From: Sarah Burrow
Sent: 20 August 2021 13:19:13
To: Maria Tomalova
Cc: Roger Spencer; Paul Cann; Phil Hamblin
Subject: RE: Planning Consultation on: AL/66/21/PL

Engineers Comments Regarding Surface Water Drainage

Thank you for consulting us on this application. The applicant has revised the surface water drainage design following the refusal of application AL/31/21/DOC. They have taken the comments on board and have attempted to deal with all of the issues raised by undertaking further infiltration testing and consulting an Arboriculturist regarding the proposed siting of the soakaway and foul drainage field. However, the infiltration testing was completed on 28/04/2021 in mid-Spring. We expect infiltration testing to be done in winter when the ground is saturated, this will give a worst case infiltration rate to be used for the purposes of the design. As the testing has been undertaken at an inappropriate time of year I request that standard condition PCENG2 is applied should you be minded to approve the application. Ultimately the EA will also need to be consulted regarding the use of infiltration, as the site is located within a Groundwater Protection Zone. Please consult the

Storm Soakaway Detail

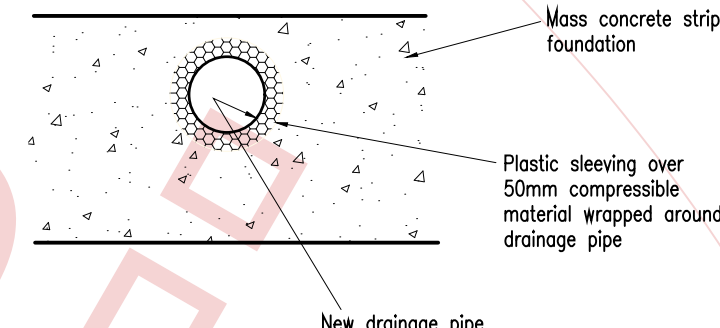
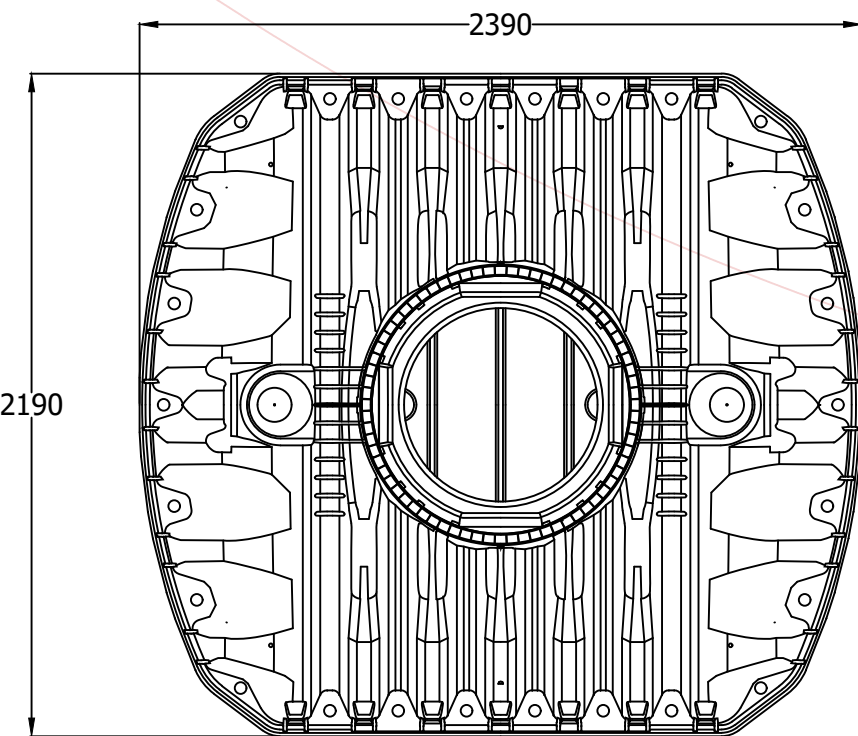
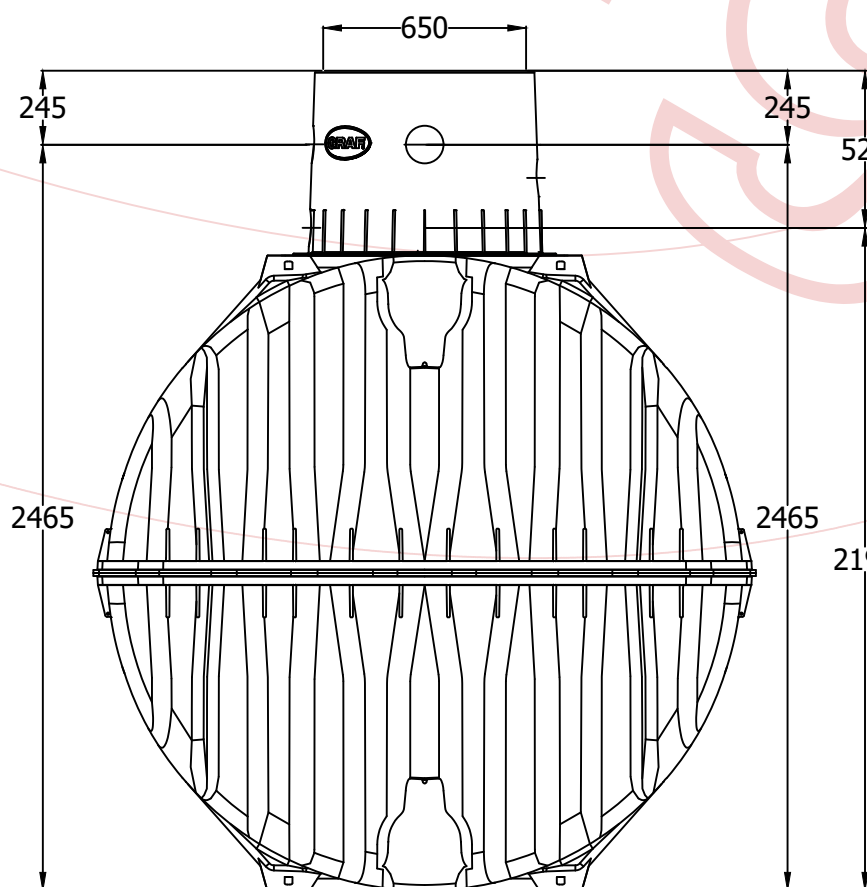
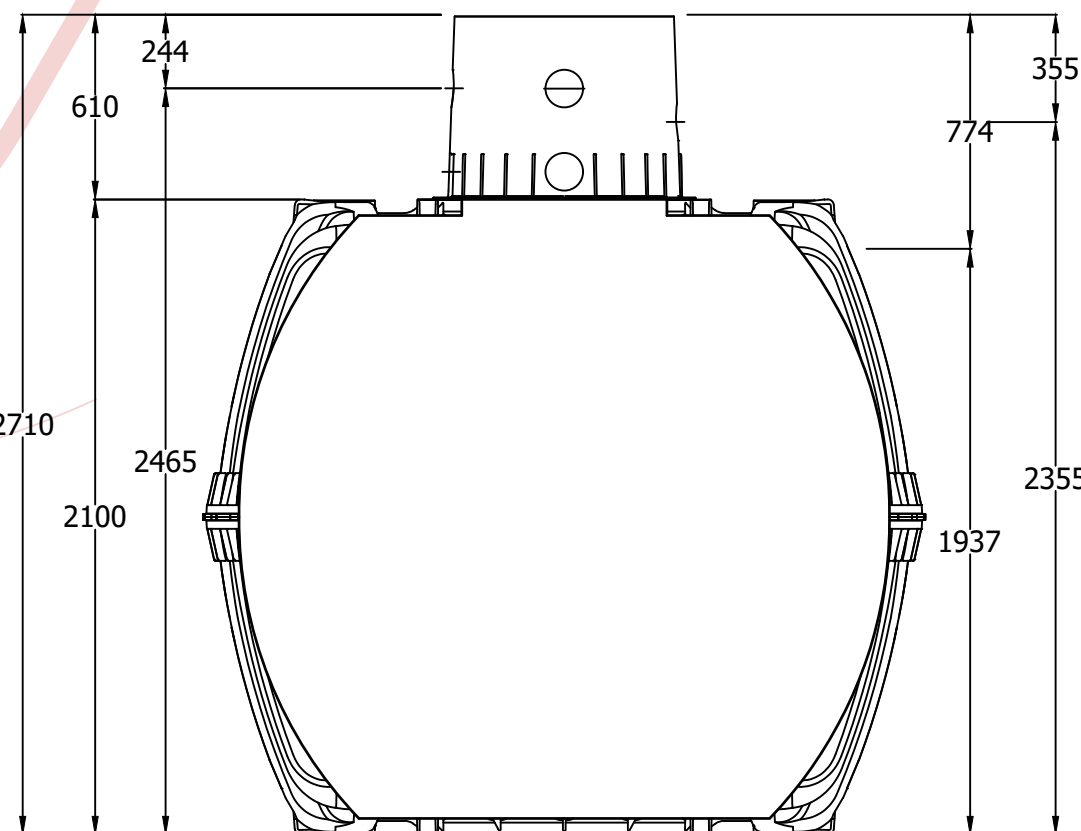
We would require the results of any appropriate testing undertaken, and the methodology to be in accordance with BRE 365 (or similar approved) – a note on a previous application for this site (AL/31/21/DOC) states that infiltration testing was undertaken in November 2020 (with a value 1.385 e-4); the same application has a supporting statement showing an infiltration value of 2.77 e-4 (applied FoS?) but I do not believe that these have been presented other than as the end result – especially the note on the drawing.

The value used for this Application is in one place 3.50 e-5 (or 3.495 e-5). This is stated as being based on an average time (implying more than one test was carried out); we require the worst case and not the average. However, from the side-by-side photos provided, it does not appear that BRE 365 was followed. Whilst the pit in the right photo is empty, it is not full in the left, implied starting condition. The document states that the results and designed are presented separately. The only other ground investigation results I can see are within the Checklist and this states the infiltration rate to be 6.99 10-5. Groundwater monitoring would suggest that groundwater was below the level at which there would be conflict with the infiltration measures proposed (the 2.4m holes remaining dry). One of the groundwater points from AL/31/21/DOC was quite close to the proposed soakaway location.

Given the evidence presented so far, I am confident that the non-conforming pit used for the testing will not unduly prejudice the results but even with the small pit, the methodology within BRE 365 would seem not to have been followed, we would welcome clarity on that. The Main Soakaway House and Garage document states that onsite infiltration test results are not available but that the value of 3.5 10-5 (noted above) is used.
